TOWN AND COUNTRY PLANNING ACT 1990 SECTION 73A CONTINUATION

Reference: H09-0395-24 **Date of Decision:** 25th June 2024
Applicant: Mr T Penny
58 Spalding Road
Holbeach
Spalding
Lincolnshire
PE12 7HG
Location: Rear Of 58 Spalding Road Holbeach Spalding Lincolnshire
Description: Proposed conversion of barn into residential dwelling - approved under H09-0701-23. Modification of Condition 2 to allow amendments to previously approved plans

The determined plans are:
3258-06 Rev. H

Elevation 03 - Rear
1 : 100

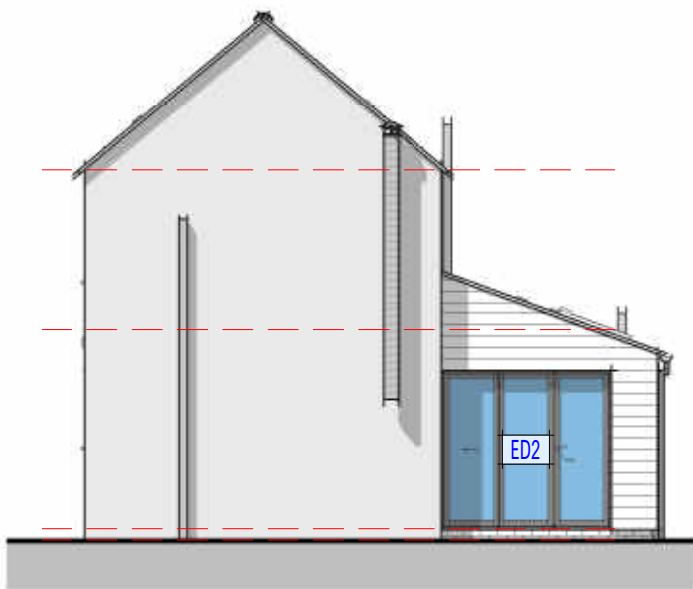
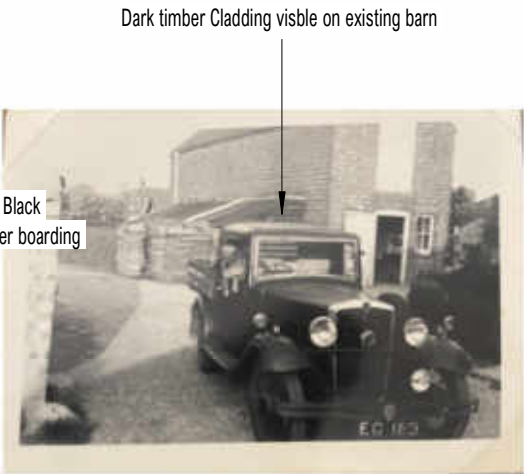
- 1 The submitted plans indicate that obscure glazed (at least level 3) bottom opening sashes with 100mm restrictors would be installed on the rear elevation at first floor level instead of the obscure glazed side opening uPVC windows presently installed. However, no specification or sections of the alternative sash windows have been submitted to demonstrate that there would be no material overlooking of the neighbouring properties to the north. Consequently, the submitted plans/details do not meet the required tests of precision and enforceability due to this deficiency. To grant planning permission on that basis would risk unacceptable planning harm to the amenity of nearby residents.
